About the application

Application number: 2021/93006	
What is the application for?:	Conversion of existing barn to form 8 dwellings, erection of 10 dwellings, demol
Address of the site or building:	Yew Tree Farm, The Village, Farnley Tyas, Huddersfield, HD4 6UQ
Postcode:

Viewport 2 - Forward Visibility (17m) - 1:250

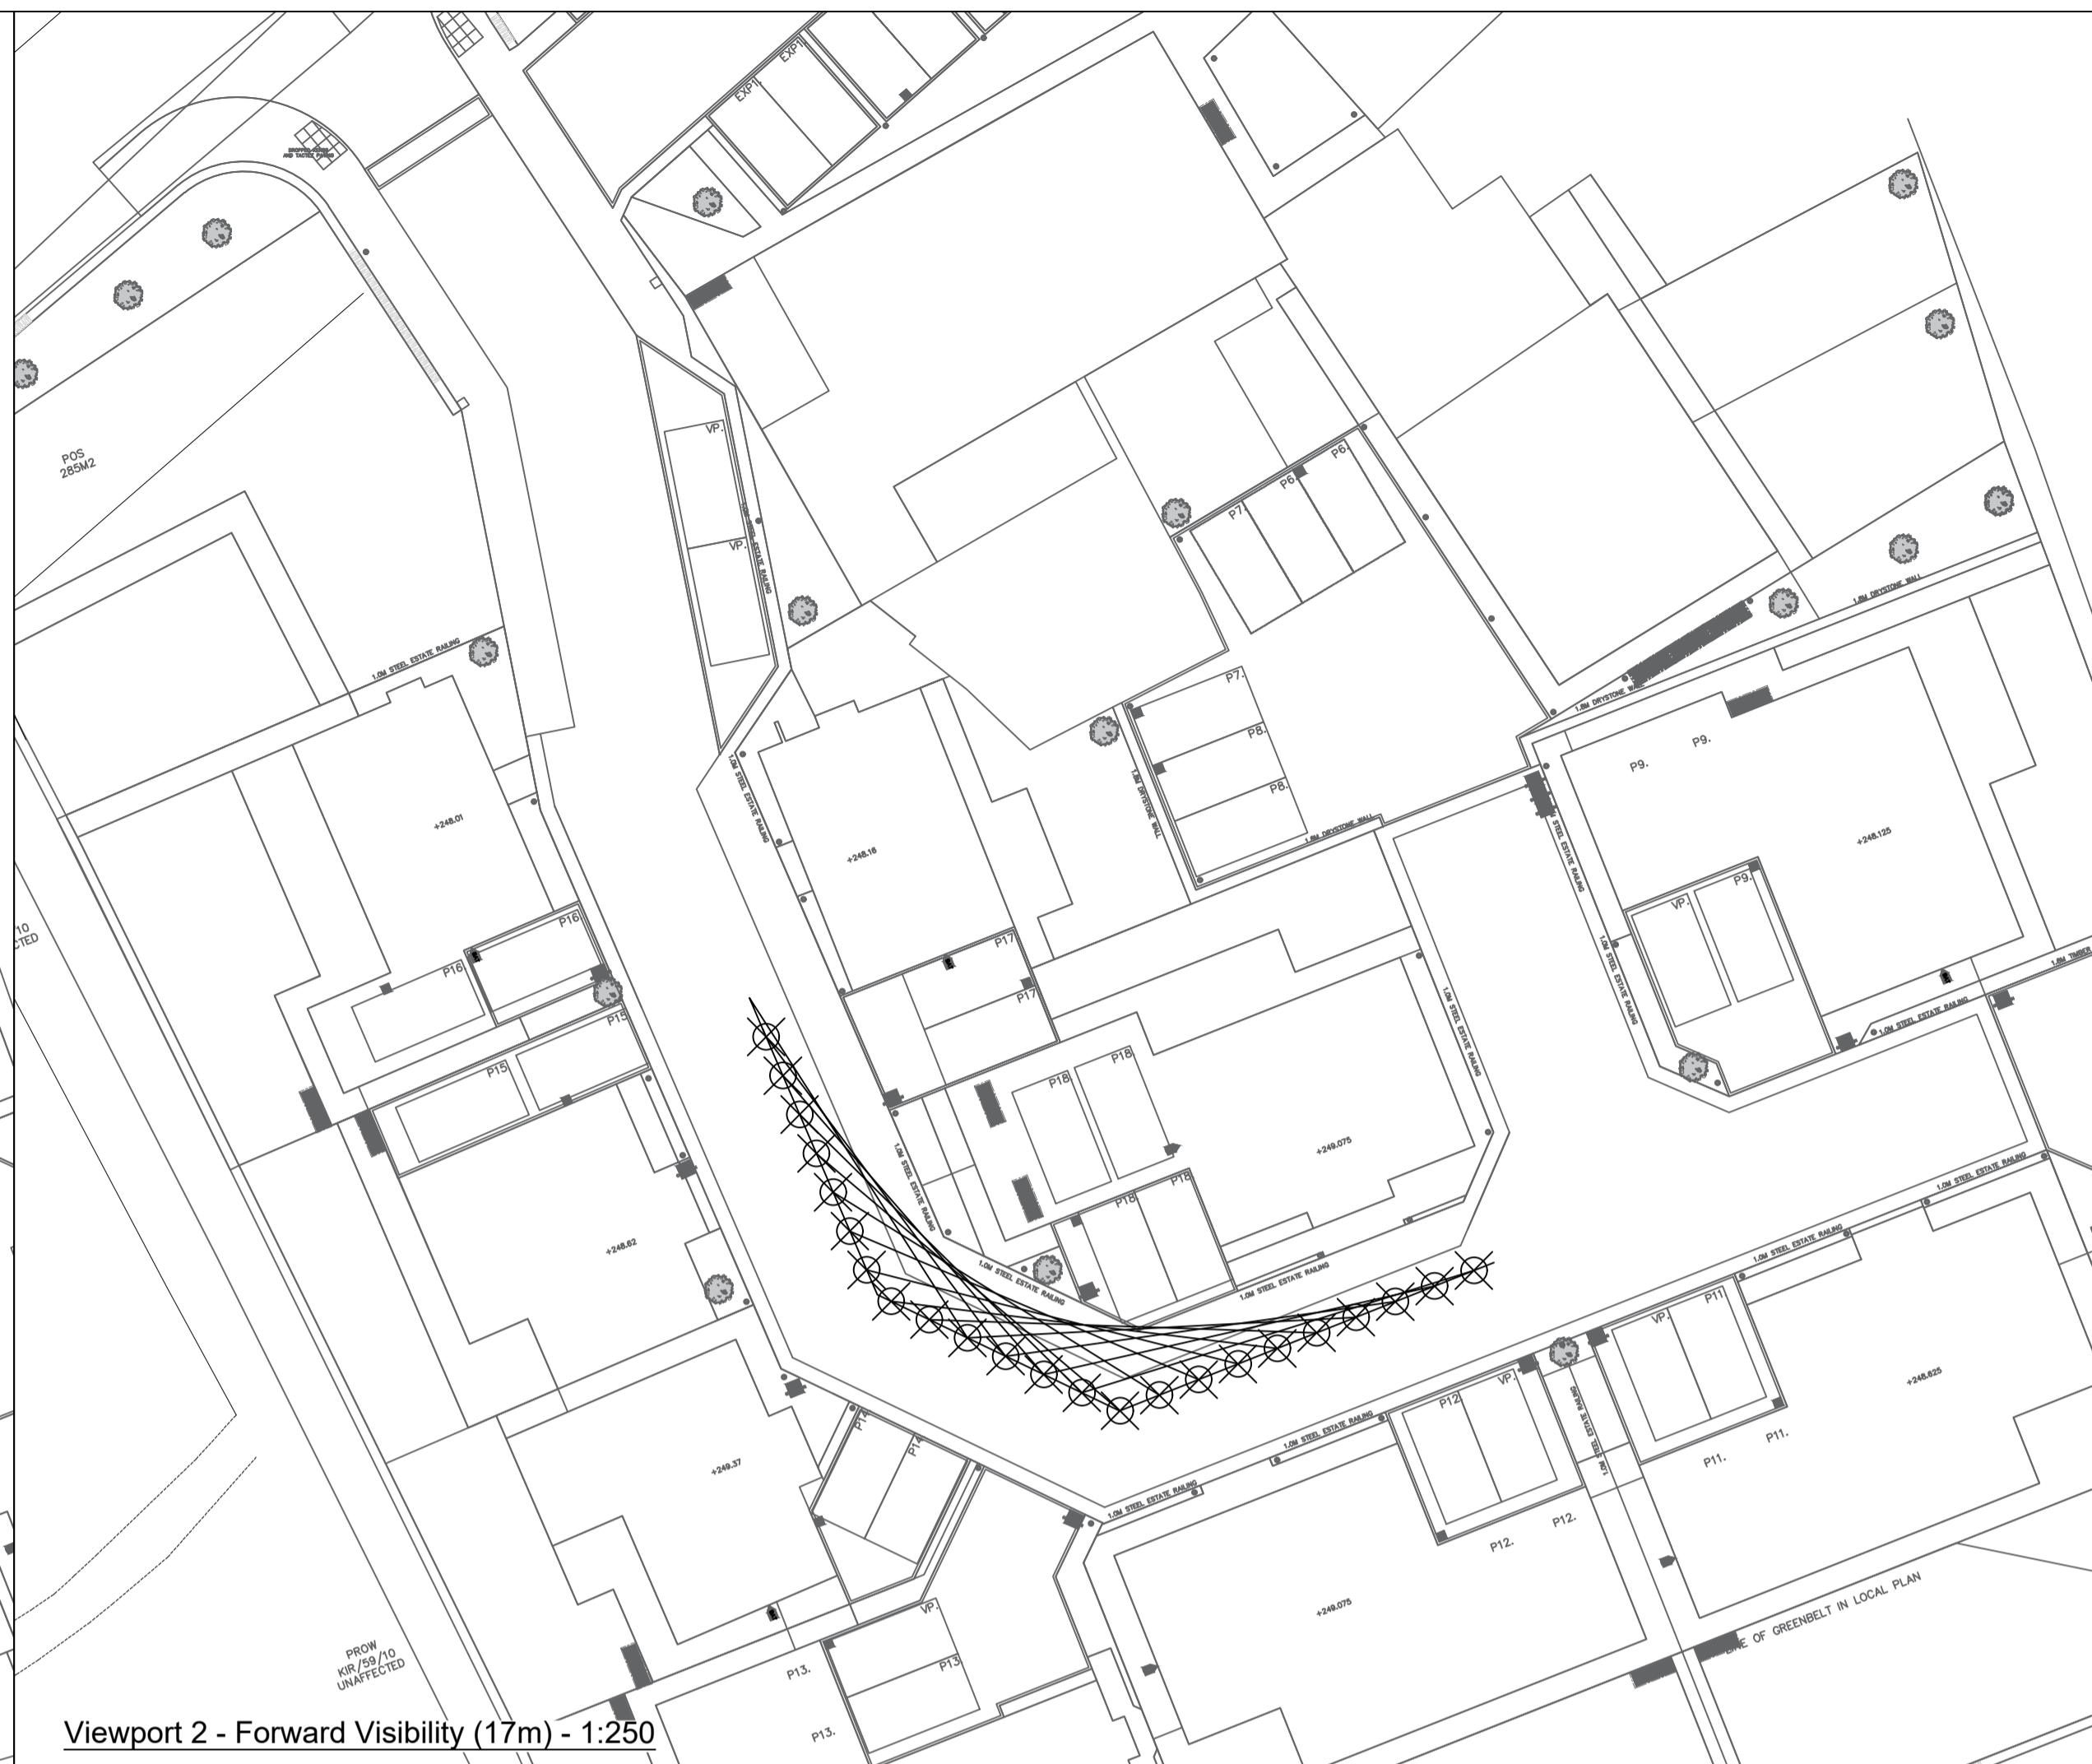
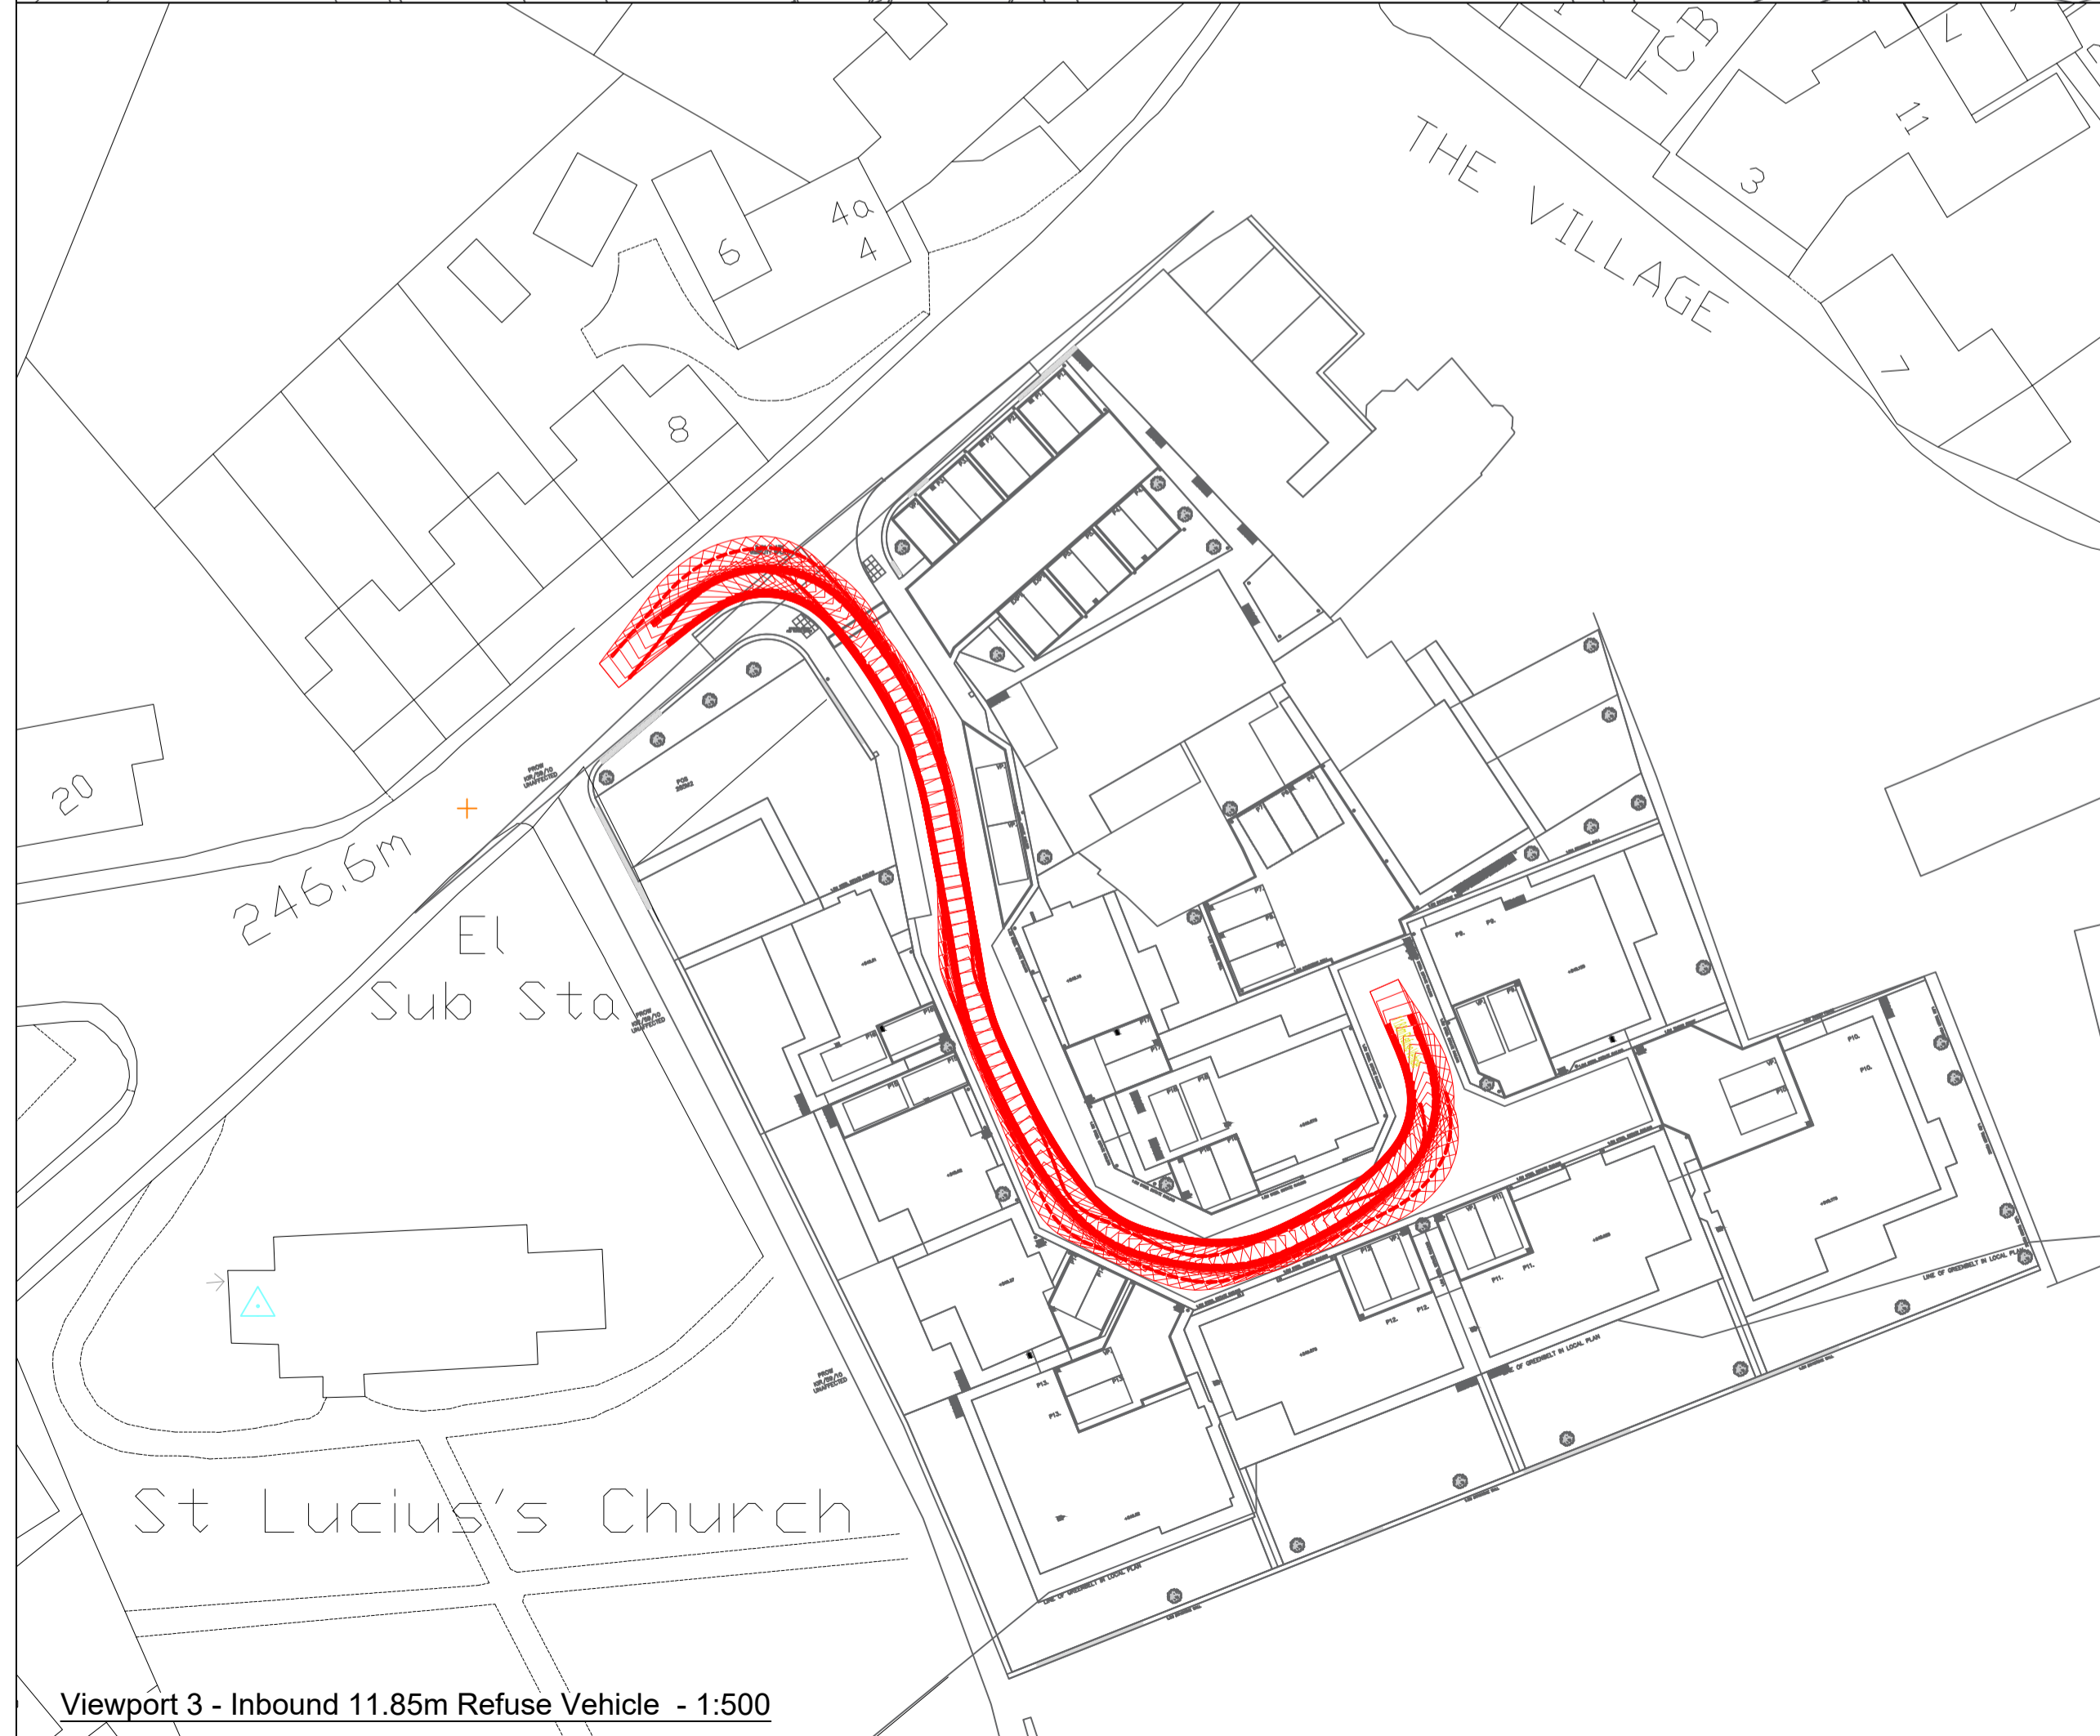
The development access proposed will mean that traffic exits onto a road with reduced visibility in either Is this not in contravention of existing highway junction visibility splay requirements? In addition cars are usually parked outside the houses immediately opposite the entrance to the development. This effectively represents an additional hazard for cars exiting the proposed development onto the main road. If the development is to proceed with the exit point proposed could traffic calming measures on the main road not be introduced to reduce the speed of passing vehicles and the potential for collision
